Our ref: HA/2021/123101/01-L01
Your ref: LU/100/21/PL
Date: 19 May 2021

CHANGE OF USE FROM OFFICE TO C3 RESIDENTIAL

FELIX DANCEWEAR 39 BEACH ROAD LITTLEHAMPTON BN17 5JA

Drawing Title
Existing and Proposed Floor Plans

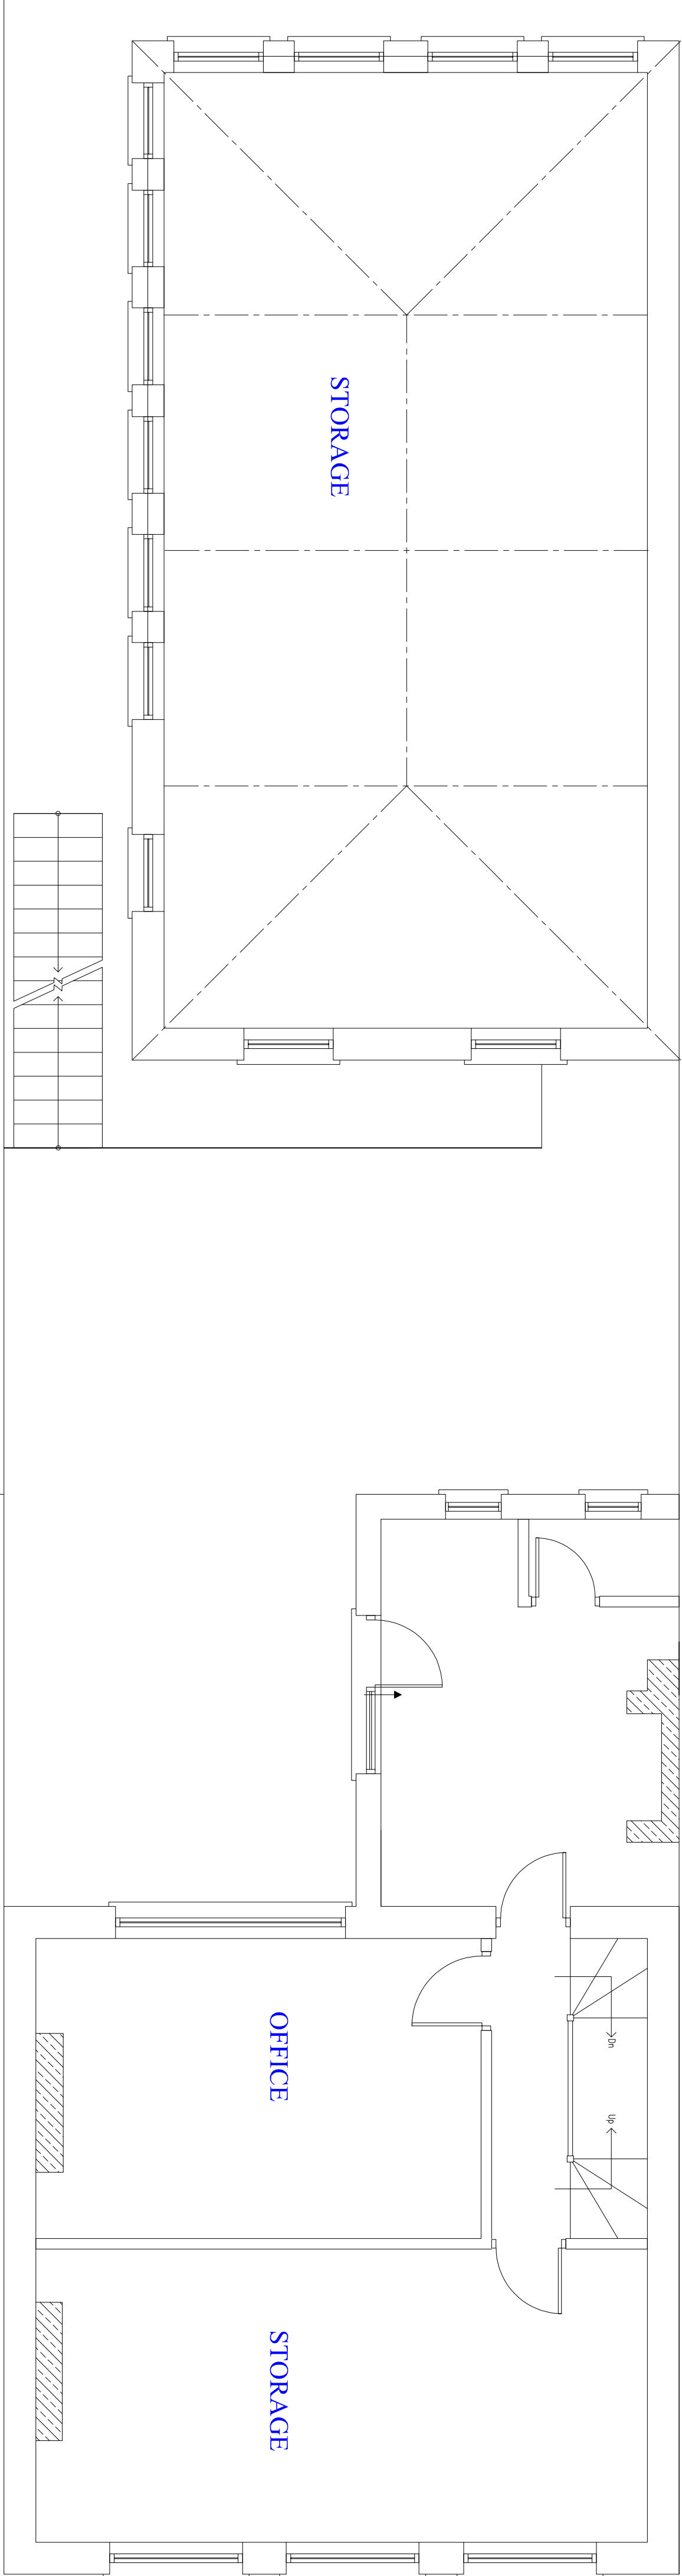
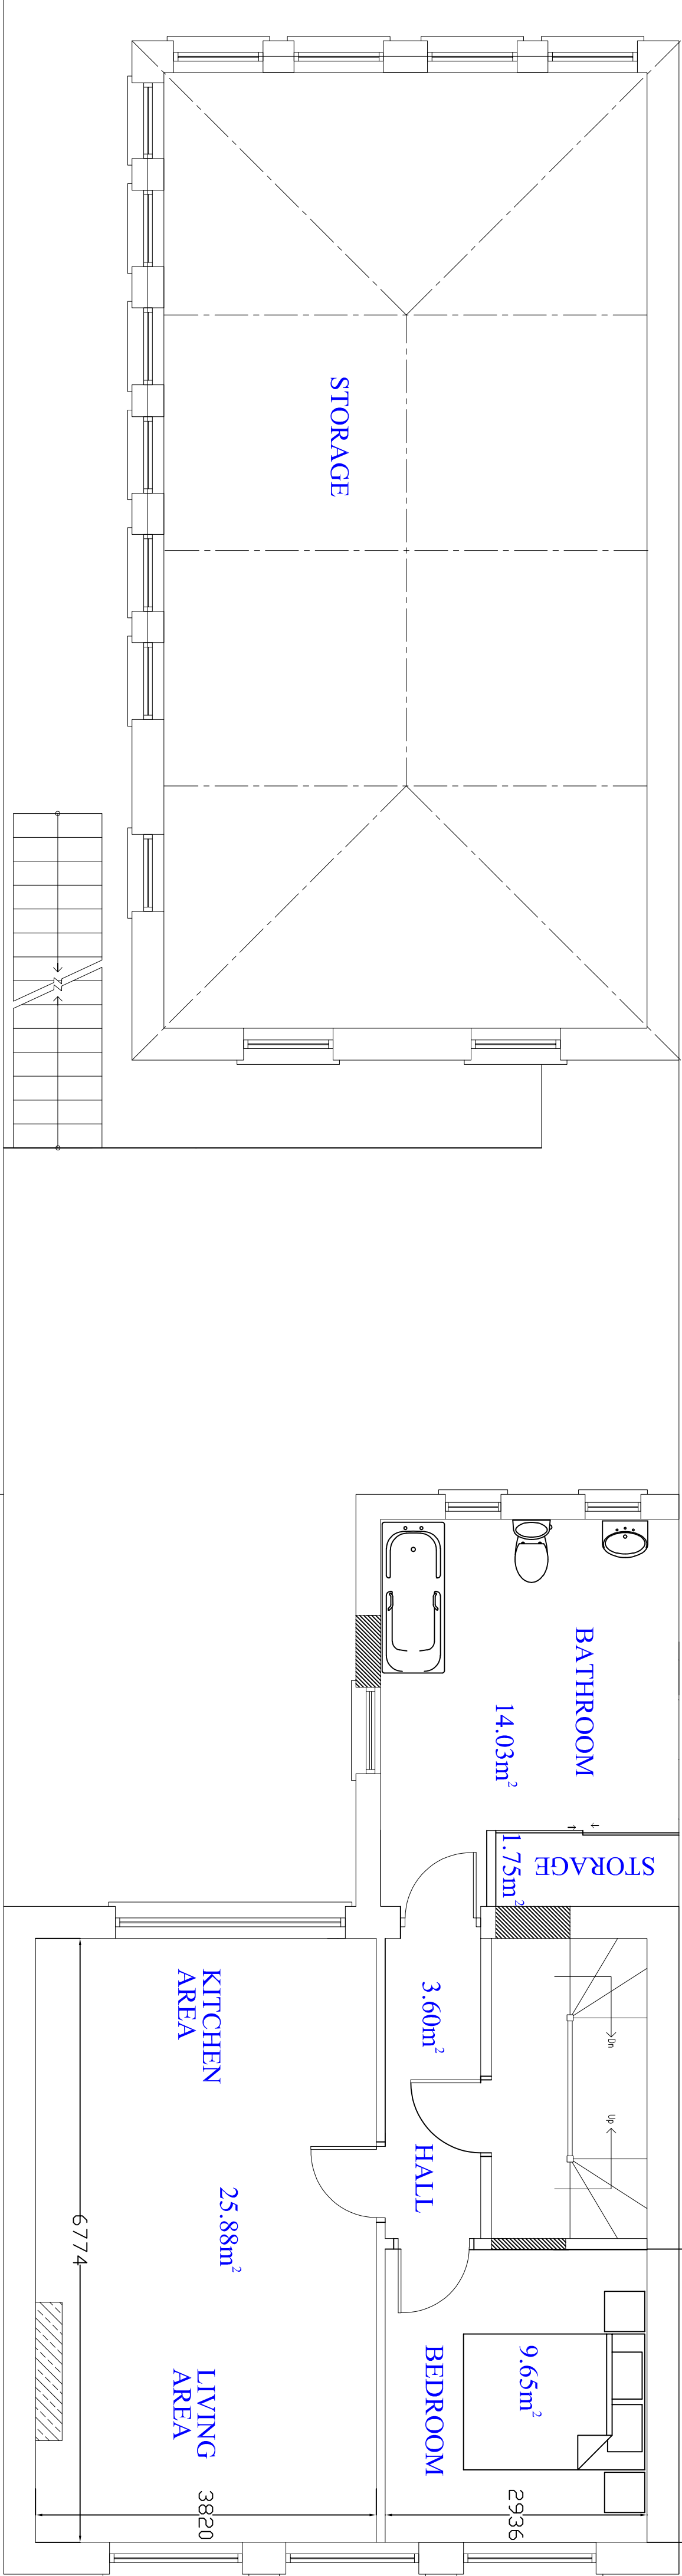
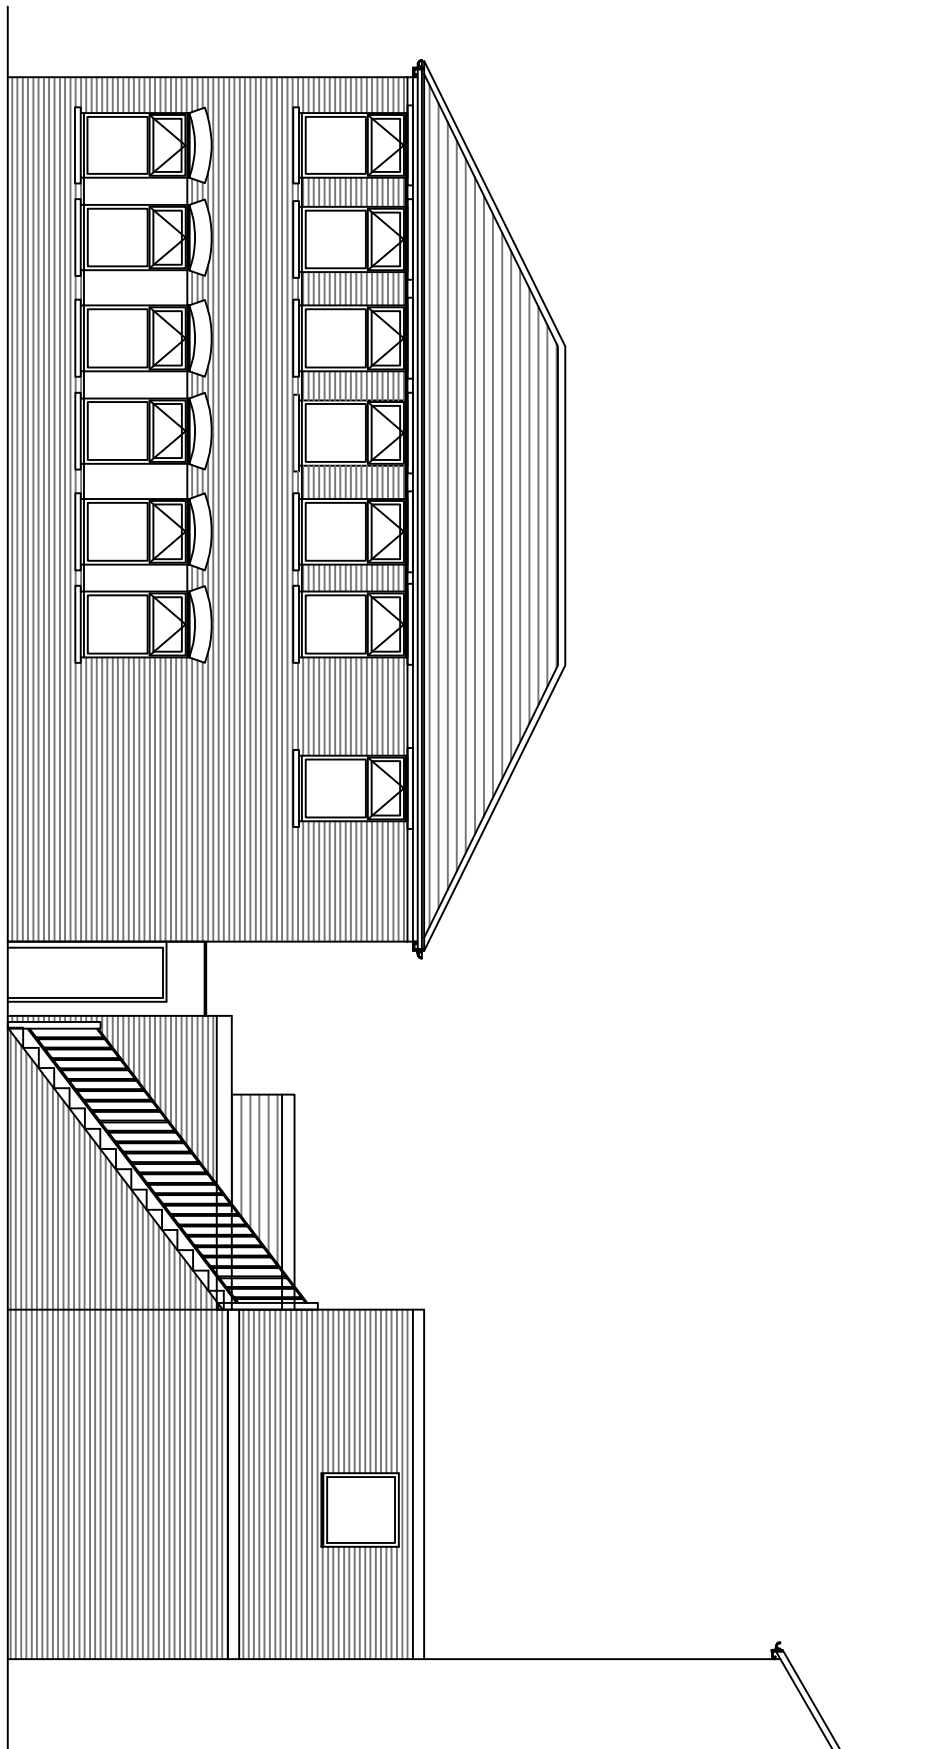
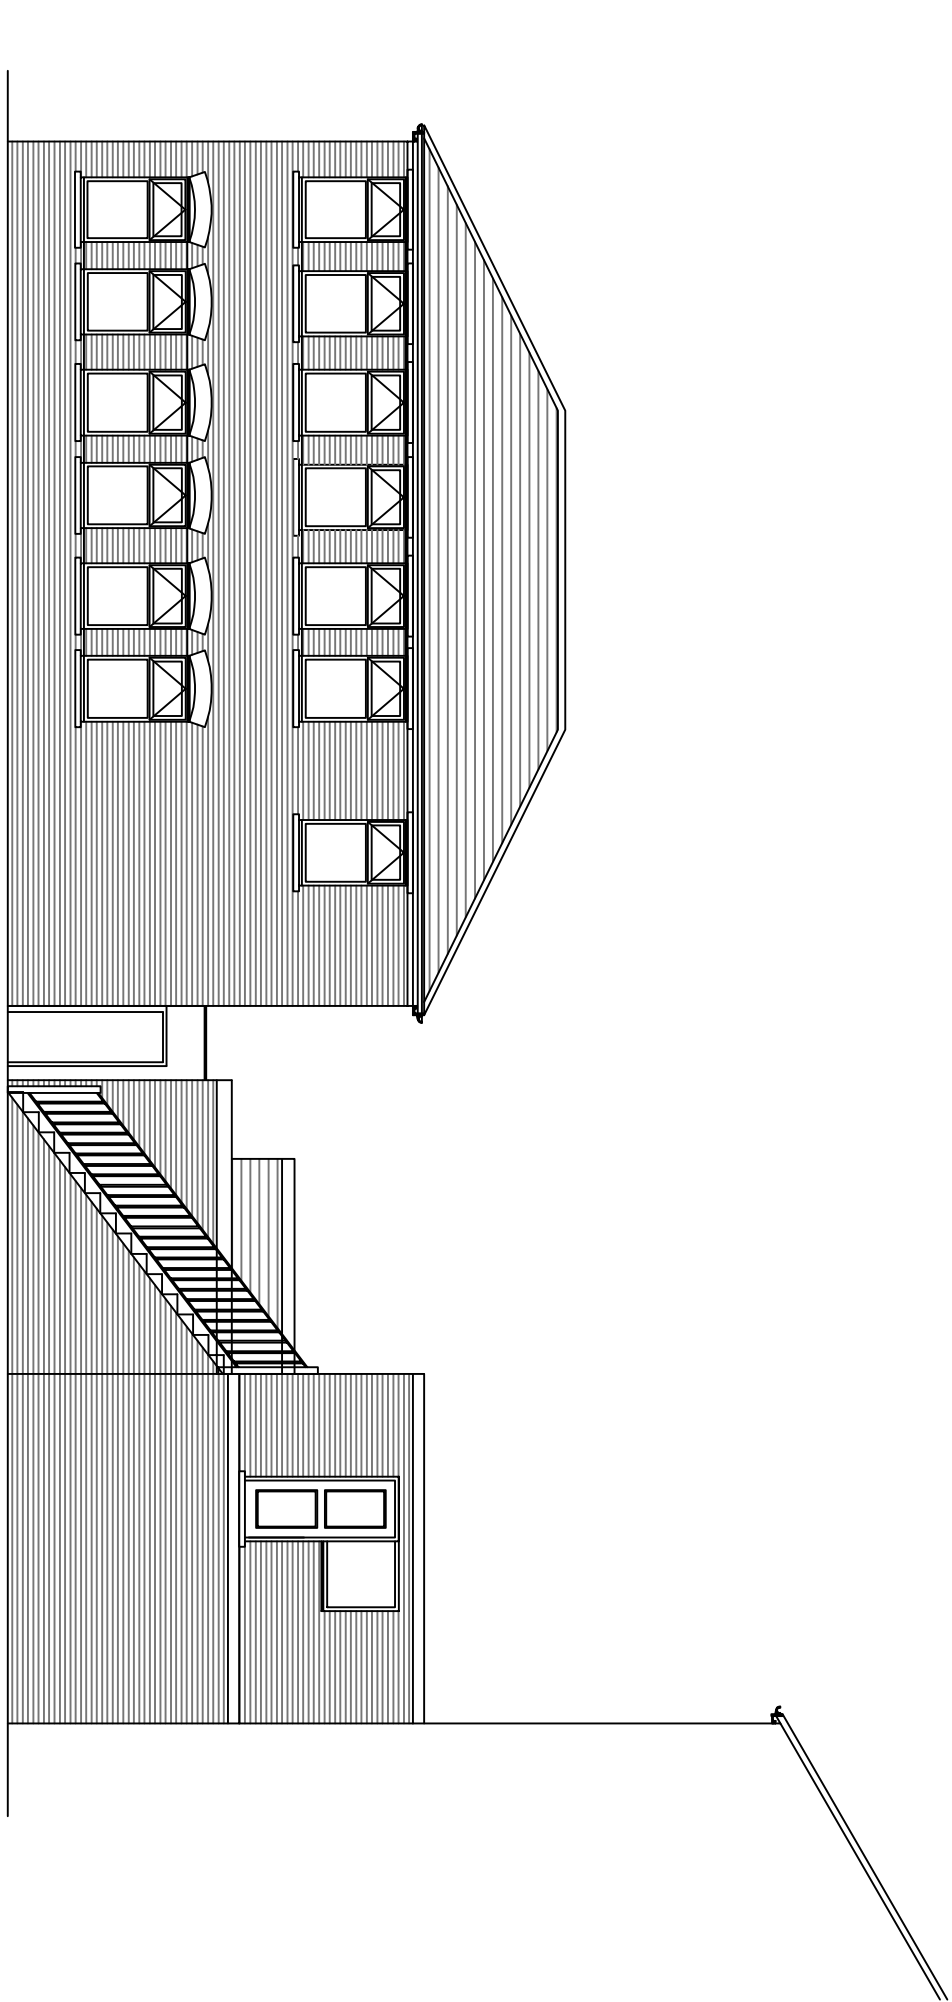
- There should be no habitable rooms on the ground floor.
